## **\*PRE-HEARING STAFF ANALYSIS\***

### **Rezoning Petition No. 2008-67**

<b>Property Owner:</b>	Sharon Arms Apartments, LLC
<b>Petitioner:</b>	Colwick Medical Partners, LLC
<b>Location:</b>	Approximately 1.7 acres on the east side of Colwick Road between Chiswick Road and Greenwich Road.
<b>Center, Corridor, or Wedge:</b>	Wedge
<b>Request:</b>	O-2 (office), to NS (neighborhood services)

C-1

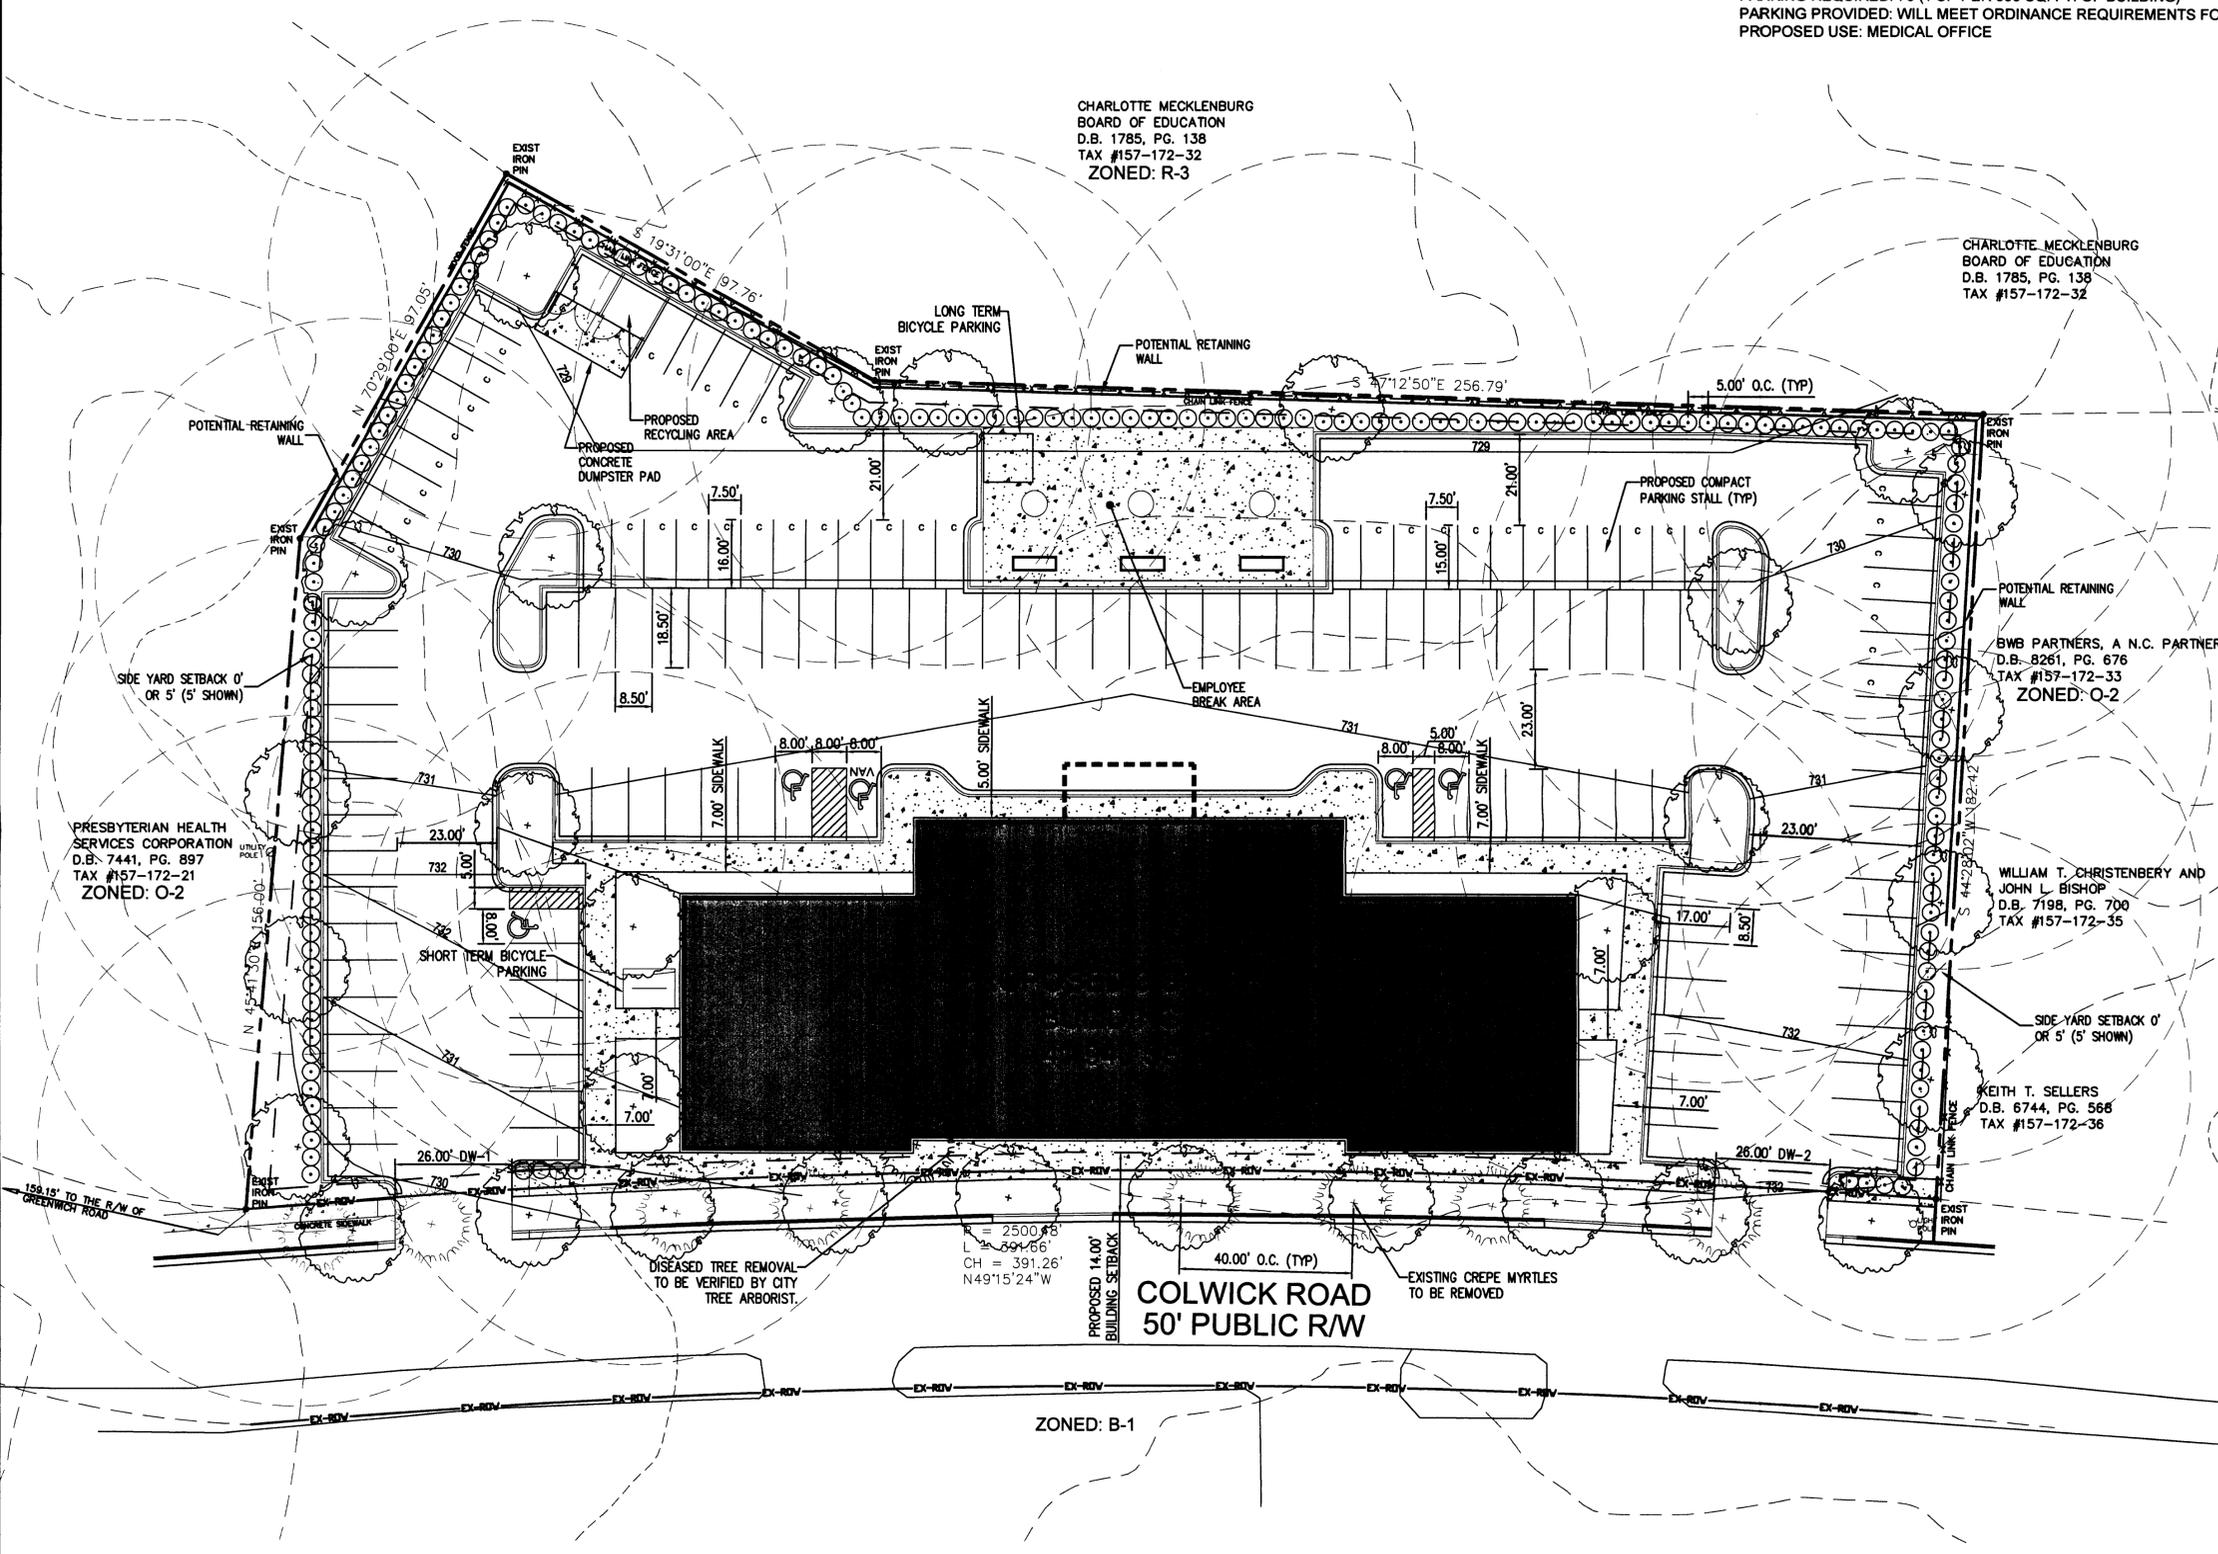
In most zoning districts the minimum amount of parking for medical office is one space per 200 square feet of gross floor area (or 5 spaces per 1,000 square feet of floor area). For the proposed 31,125 square feet of medical office in this petition the necessary parking would be 156 spaces. Since none of the uses permitted in the NS district are excluded on this site plan we can only estimate the additional parking needed for the “NS uses”. A reasonable example would be a 5,000 square foot restaurant and 5,375 square feet of “other business uses”. These uses would generate the need for an additional 62 spaces - a total of 218 spaces. With only 159 spaces provided there is a 27.1% deficiency in needed parking.

Staff has sought to find an up-to-date parking demand ratio for medical office buildings based on empirical studies. The Institute of Transportation Engineers conducted a study in 2007 and found that a parking ratio of 4.5 spaces per 1,000 square feet of medical office floor area would meet parking demands 85% of the time. Staff is willing to use this ratio. It results in an overall parking demand of 202 spaces on this project and a supply of 159 - a 21.3% deficiency.

There is no open space or tree save area proposed on this site. An open space area consisting of existing trees, an employee break area, water quality rain gardens, or similar amenities are needed on the site.

On-street parallel parking must be a minimum of 22 feet in length and must be at least 20 feet from all driveways. The on-street parking proposed does not meet these standards. Complying with these standards will result in the loss of two parking spaces from those shown on the site plan.

The “potential connection for shared parking” noted on the site plan needs to be modified. Since the uses on both sites are predominantly the same, “sharing” would probably not be allowed. Alternatively, a long term lease could allow additional off-site parking.

Note #9 needs to clarify that this development will comply with the Post Construction Controls Ordinance.
